**KIRKLEES METROPOLITAN COUNCIL
INVESTMENT & REGENERATION SERVICE**

DELEGATED DECISION TO DETERMINE PLANNING APPLICATIONS

Reference No:	2024/62/92807/E
Site Address:	42, Storthes Hall Lane, Kirkburton, Huddersfield, HD8 0PT
Description:	Installation of air source heat pump
Recommending Officer:	Jennifer Booth

DECISION - REFUSED

Heat pump for 42 Storthes Hall Lane

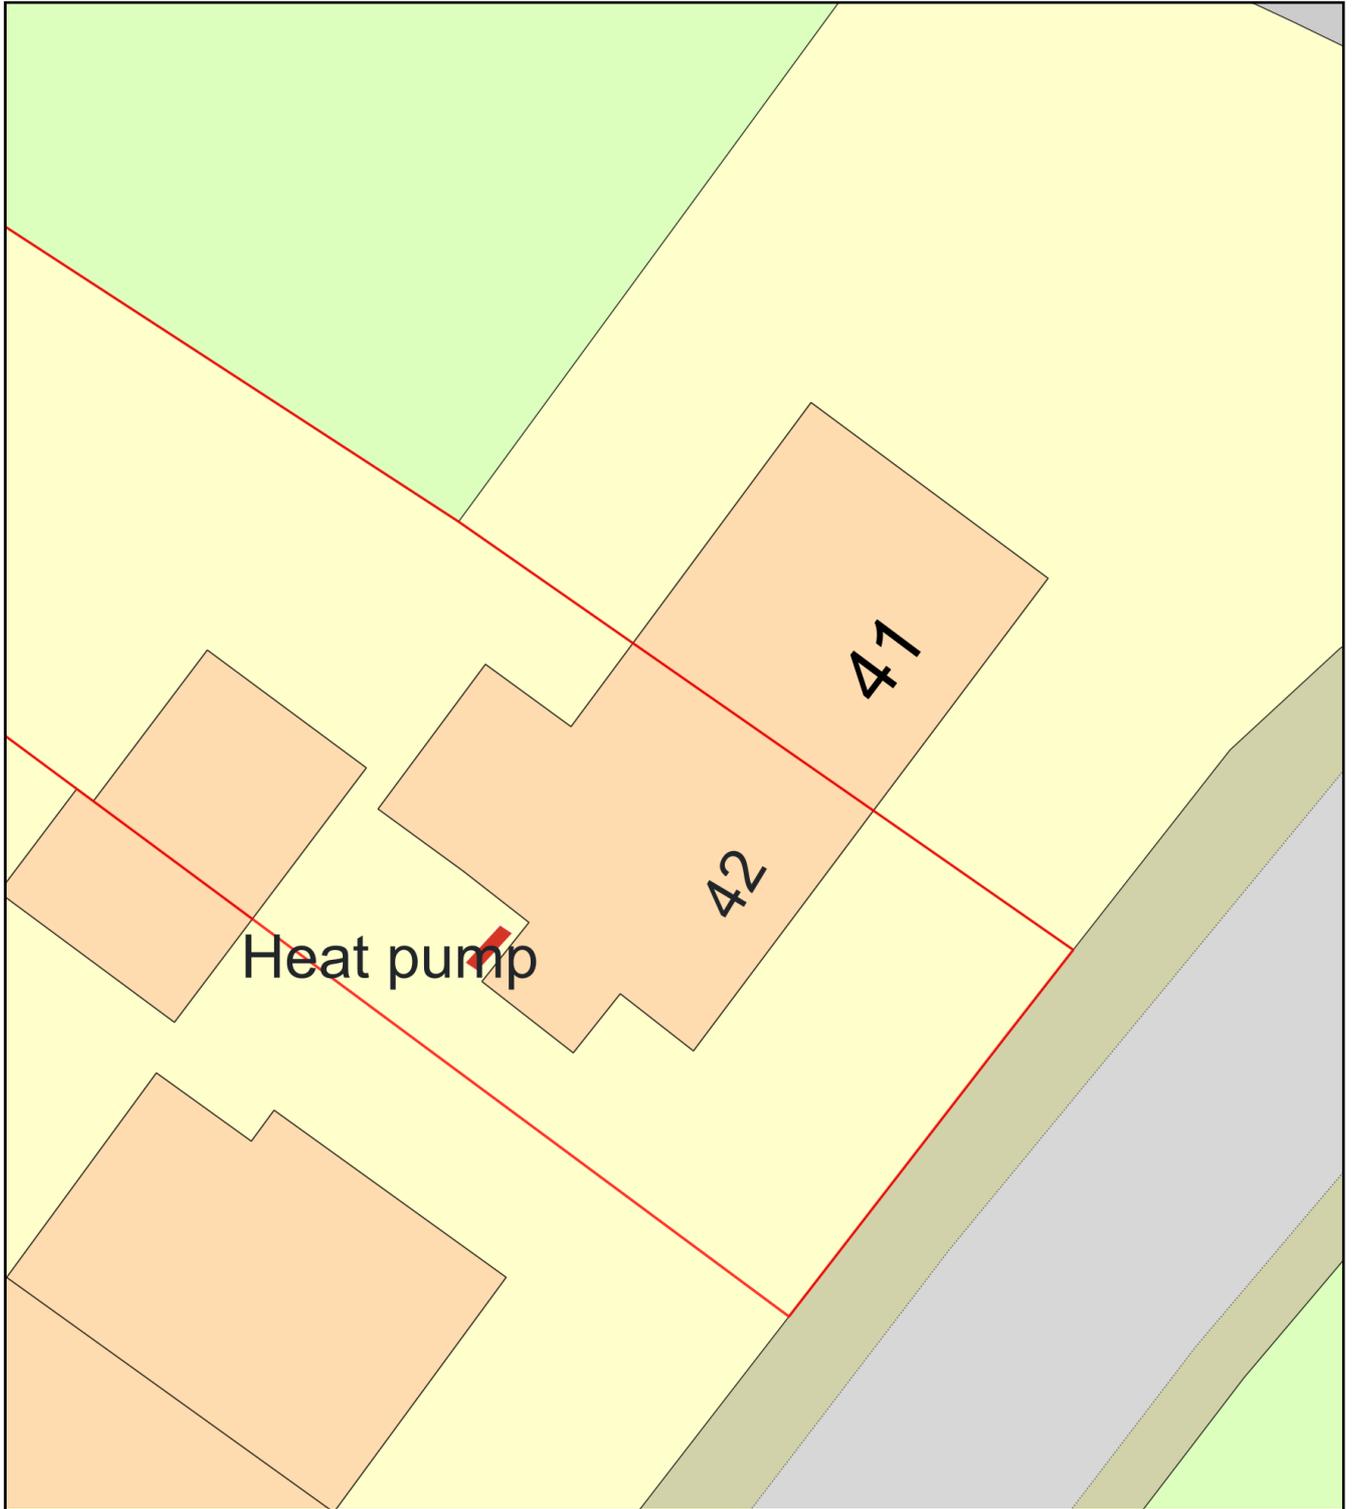
The unit would be sited on the side elevation behind the porch.

The ASHP unit would be located on the side of the dwelling facing towards the adjacent property. The applicant has submitted an MSC020 certificate with the scheme. However, this only confirms that the level of noise would exceed the allowance under permitted development. This does not demonstrate how the works would be carried out and operated without detriment to the amenities of the occupiers of the adjacent dwelling from the noise generation of the ASHP unit. There are concerns that its operation would result in noise nuisance to adjacent occupants. The proposals are therefore considered to be unacceptable in terms of impact on residential amenity and fail to comply with Policies LP24 & LP52 of the Kirklees Local

The applicant has failed to demonstrate that the Air Source Heat Pump would be operated without harm to the amenities of the occupiers of the adjacent property, 43 Storthes Hall Lane from noise generated by the Unit. To permit
